**City of Portland, Maine - Building or Use Permit Application**  
 389 Congress Street, 04101 Tel: (207) 874-8703, Fax: (207) 874-8716

<b>Permit No:</b> 05-1802	<b>Issue Date:</b>	<b>CBL:</b> 033 C019001
------------------------------	--------------------	----------------------------

<b>Location of Construction:</b> 38 ALDER ST	<b>Owner Name:</b> MID-TOWN PROPERTIES LLC	<b>Owner Address:</b> PO BOX 641	<b>Phone:</b>
<b>Business Name:</b>	<b>Contractor Name:</b> Bill Simpson	<b>Contractor Address:</b> P.O. Box 641 Freeport	<b>Phone</b> 2078656678
<b>Lessee/Buyer's Name</b>	<b>Phone:</b>	<b>Permit Type:</b> Alterations - Multi Family	<b>Zone:</b>

<b>Past Use:</b> Residential multi - family	<b>Proposed Use:</b> Residential multi - family- repair floor stringers, sub floor & 6"x6" Beam in apt#1 sheetrock work in apt. 1 & 2	<b>Permit Fee:</b> \$111.00	<b>Cost of Work:</b> \$9,800.00	<b>CEO District:</b> 1
<b>Proposed Project Description:</b> repair floor stringers, sub floor & 6"x6" Beam in apt#1 sheetrock work in apt. 1 & 2		<b>FIRE DEPT:</b> <input type="checkbox"/> Approved <input type="checkbox"/> Denied	<b>INSPECTION:</b> Use Group: Type	
		Signature:	Signature:	
<b>PEDESTRIAN

FLOOR PLAN
3840 ALDER STREET
BILL SIMPSON

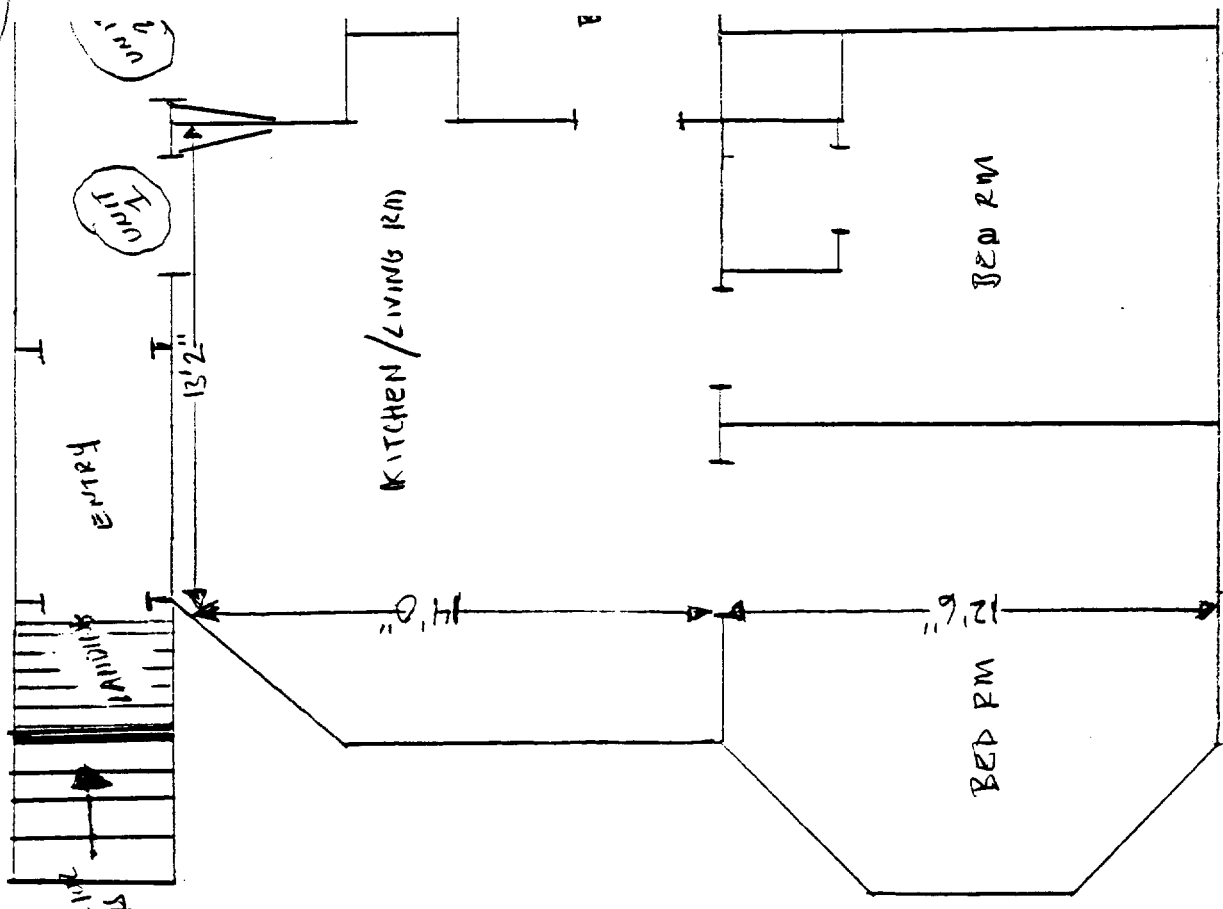
1/31/06-tmm: left message w/owner - need sound tranmission info, opening size, what floor is apt located on, elec plumb?, penetrations in rating, ceinlings being resheetrocked?

- 1) All penetrations between dwelling units and dwelling units and common areas shall be protected with approved firestop materials, and recessed lighting/vent fixtures shall not reduce the (1 hour) required rating.
- 2) Permit approved based on the plans submitted and reviewed w/owner/contractor, with additional information as agreed on and as noted on plans.
- 3) As discussed, hardwired interconnected battery backup smoke detectors shall be installed in all bedrooms, protecting the bedrooms, and on every level.
- 4) Separate permits are required for any electrical, plumbing, or heating.
